# KITTITAS COUNTY

### MEMORANDUM

**TO:** All Staff  
**FROM:** Public Works Plan Review Team  
**DATE:** November 28<sup>th</sup> 2023  
**SUBJECT:** RU-23-00001 Teanaway Ridge

Figure 1. This image was part of WDFW’s comments in 2016 for the Yakima River Campground (CU-15-00002, SD-15-00001, SP-15-00001).

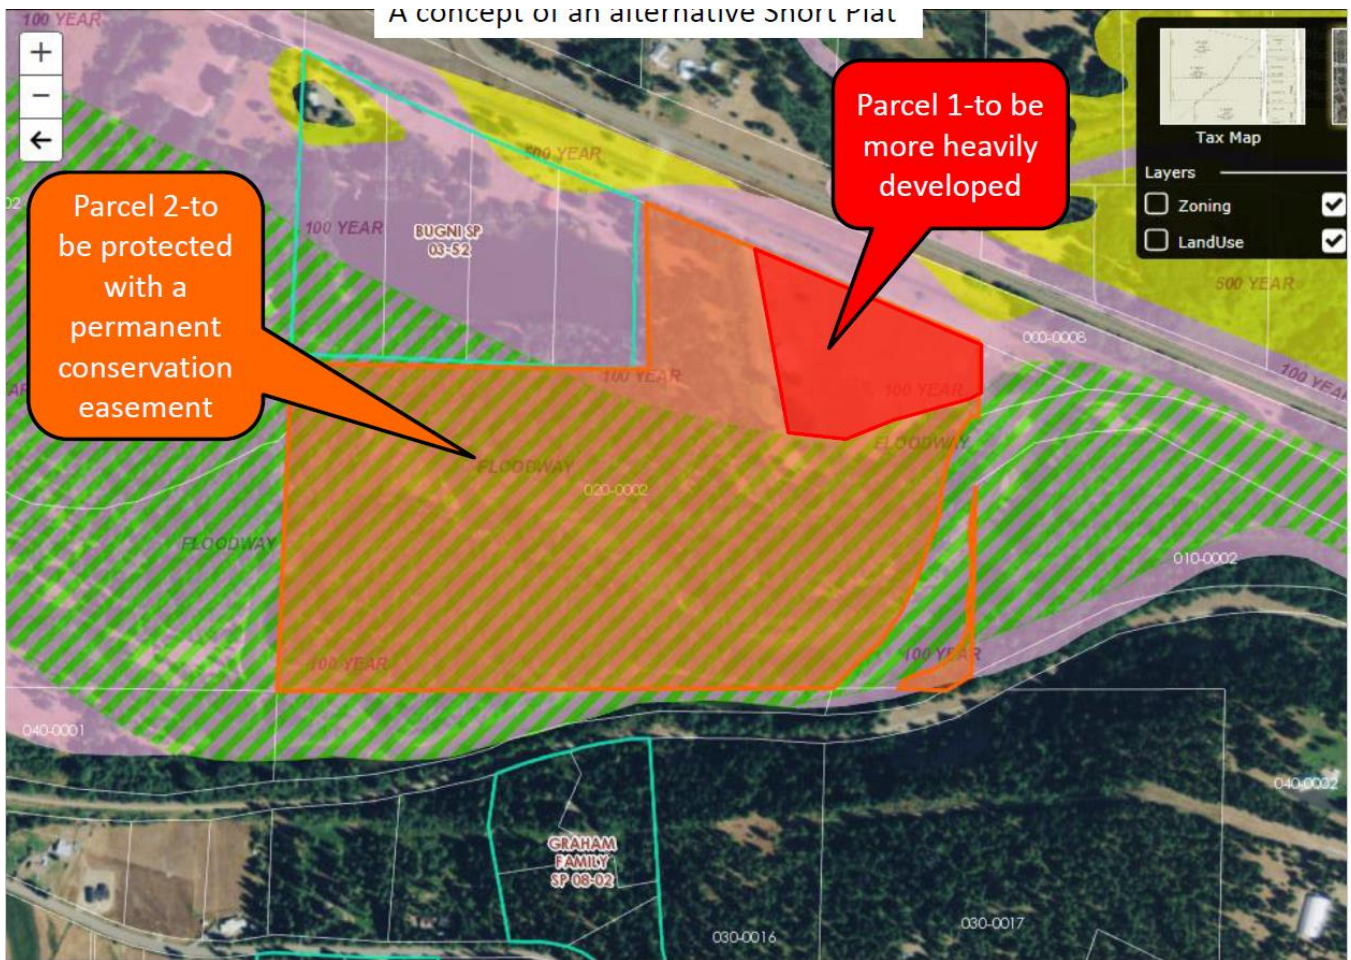
The critical areas report provided references updates as of March 2023, but does not reflect the culvert removal between Wetlands A and AA that occurred during a flood in June 2022. The wetland report still shows the now removed culvert separating the two wetlands and Shoreline (KCC 17B) vs. Critical Areas (KCC 17A) jurisdiction. The report also makes no mention of the change of conditions in the northwestern portion of the property that breached the pond berm on the adjacent parcel to the west. **We request further review and consideration of any wetland identification or classification given the water crossing structure is no longer present and the pond is breached. It is possible this review may result in this area being a single wetland within Shoreline jurisdiction.** WDFW has determined that a Hydraulic Project Approval (HPA) is required for work within the pond and channel to mitigate impacts to fish life because there is connectivity with the mainstem Yakima River.

The Channel Migration Zone Summary Memo clarified the potential for lateral migration at the project location. The report identifies more rapid migration near the western portion of the property and the

properties immediately upstream of the subject parcels but does not assess the potential for an avulsion on the WDFW property that could travel through the adjacent pond and onto the western portion of the property. In June 2022, flood waters breached the berm of the pond and flooded the northwestern portion of the property where several RV sites have been proposed in previous site plans. WDFW has experienced more frequent flooding of the road to our water access site upstream of this project site and to the best of our knowledge, the pond berm has not been repaired. We believe there is a relatively high flood risk on the northwestern portion of the property (see photos in our 2022 letter) that is not reflected in the information available to review. **If the northwestern portion of the property is proposed for development in the new site plan, we request further evaluation of the potential for avulsion and/or flood risks through this area.**

Without an updated site plan and based on the information provided in the updated critical areas report and CMZ summary along with the existing infrastructure, **WDFW believes the image presented in our 2016 comments for the Yakima River Campground Conditional Use Permit (Figure 1) represents the area most suitable for a Reasonable Use Exception on this property and meets the intent of KCC 17A.01.060(2).**
